Subject: RE: Attached letter from Kirklees Council regarding application number 2026/90593 at location Penistone Road/, Rowley Lane, Fenay Bridge, Huddersfield, HD8 0JS

Further to the DOC application submitted in connection with the above, I would like to advise the following:

| TITLE: CONDITION 25 & 26<br>ROAD 3/ ATTENUATION TANK |                     |                |                |

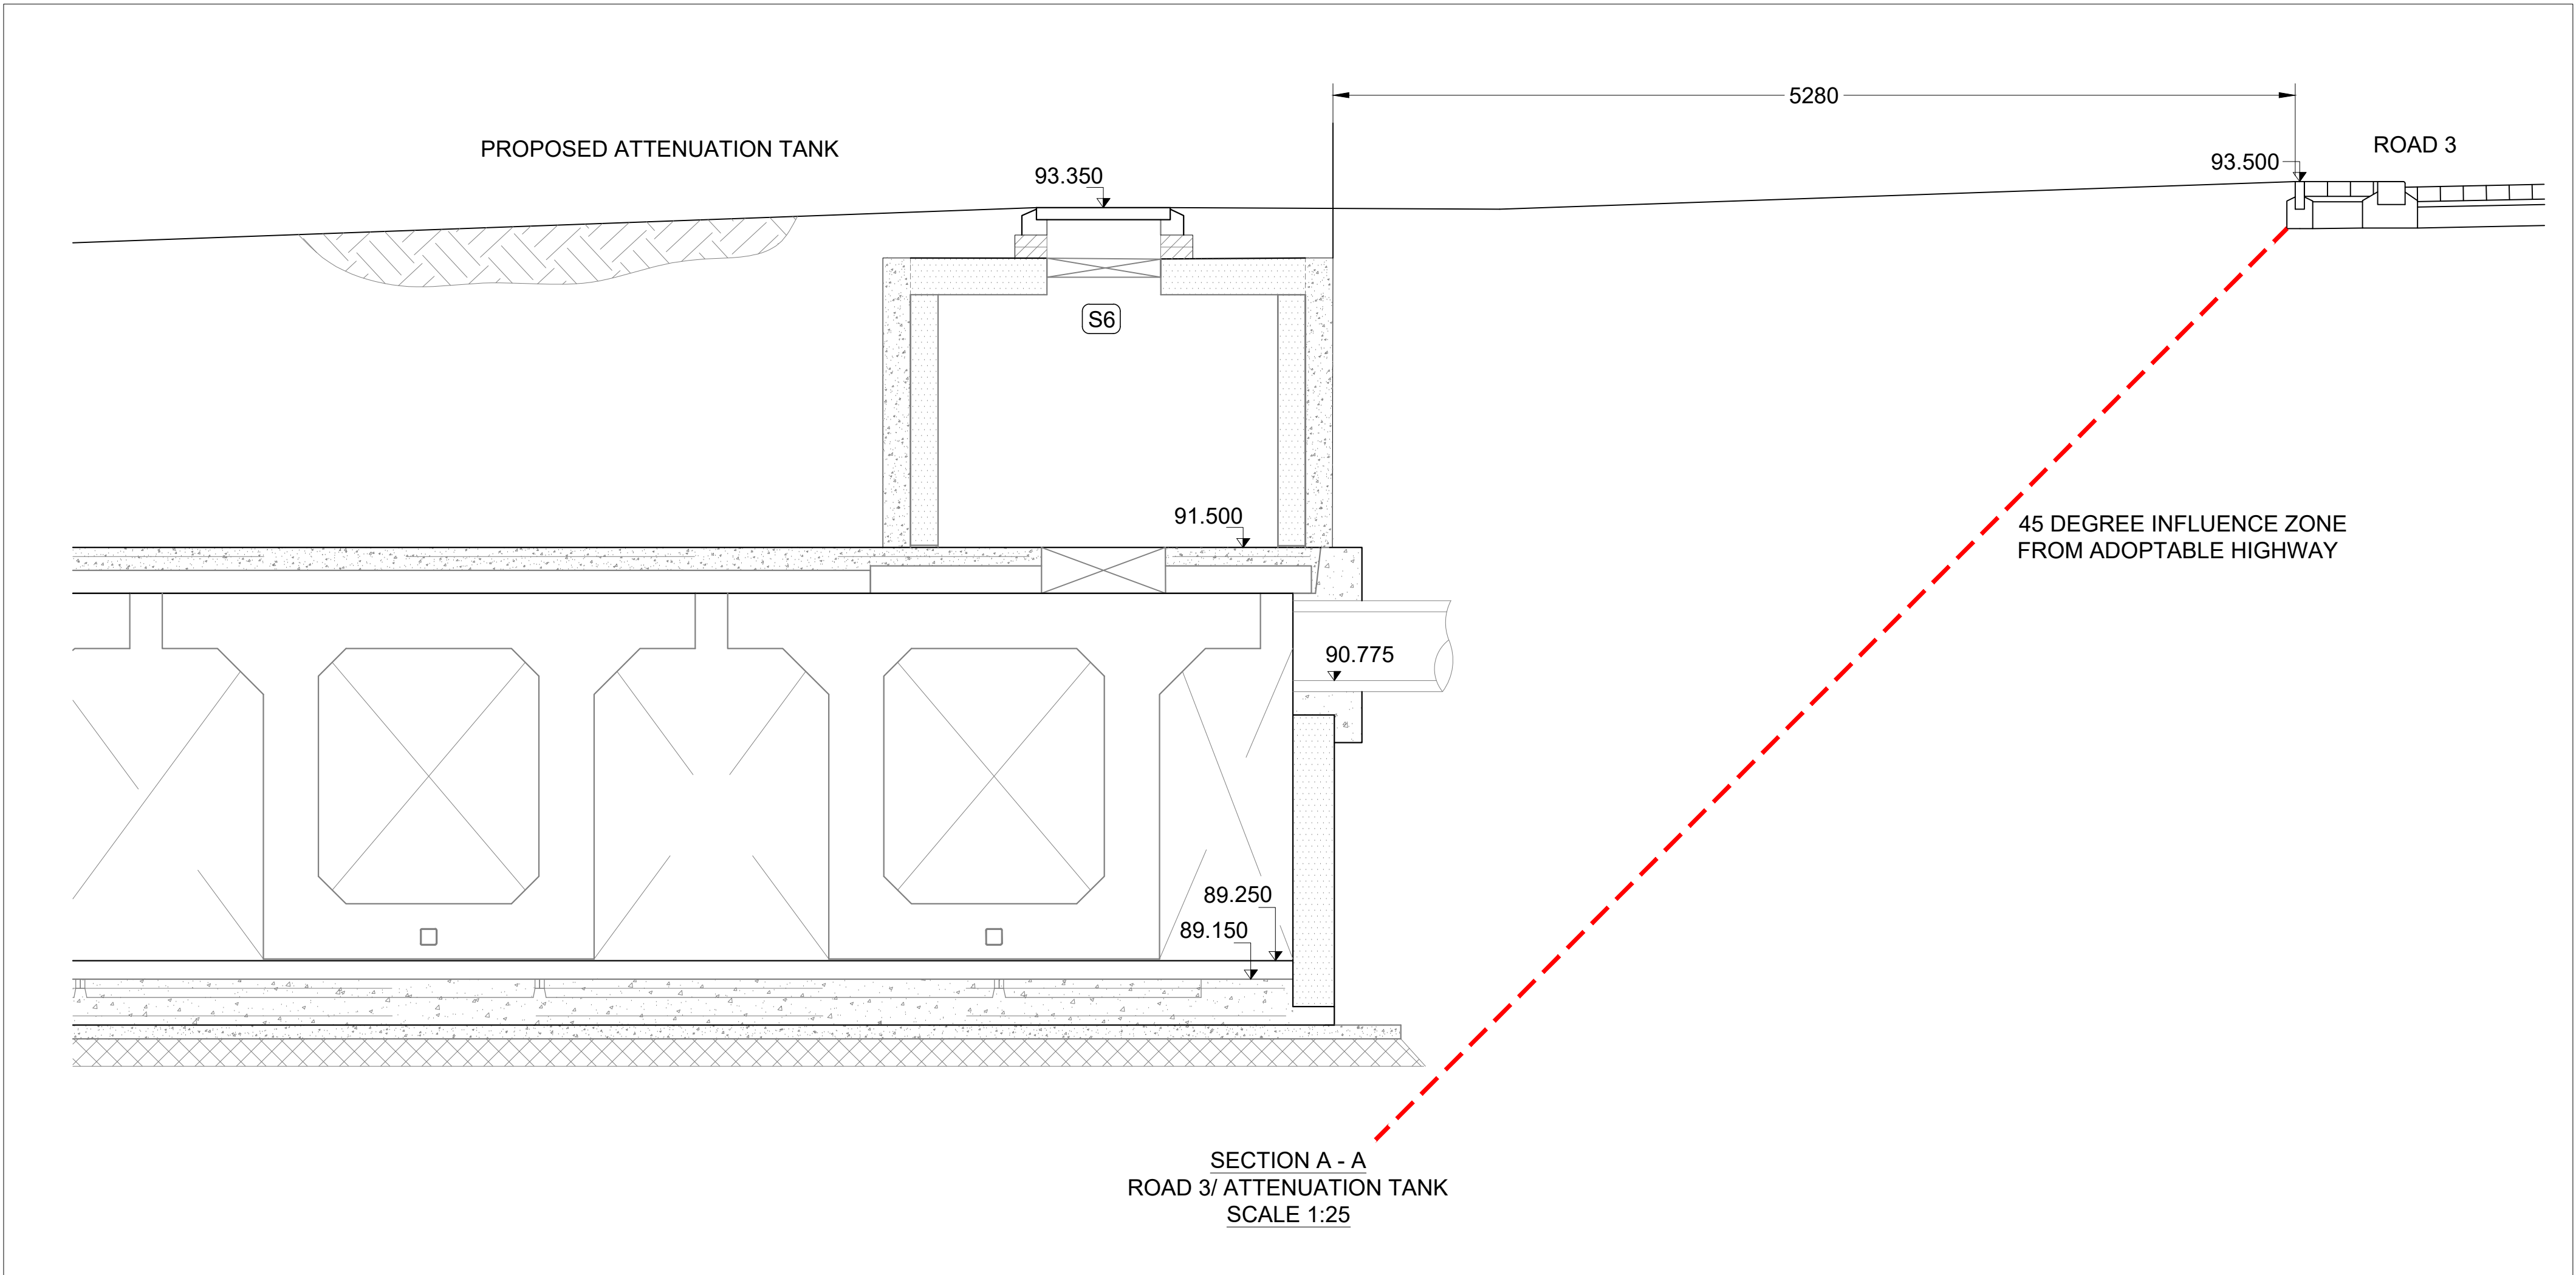
Condition 25 (retaining walls)- This condition can be partially discharged pending the submission of a satisfactory “Construction Compliance Certificate” and “As Built” drawings upon the completion of the works.

Condition 26 (internal roads/footways/footpaths) – This condition can not be discharged pending the submission and approval of a “Construction Compliance Certificate” and “As Built” drawings for oversize manholes.
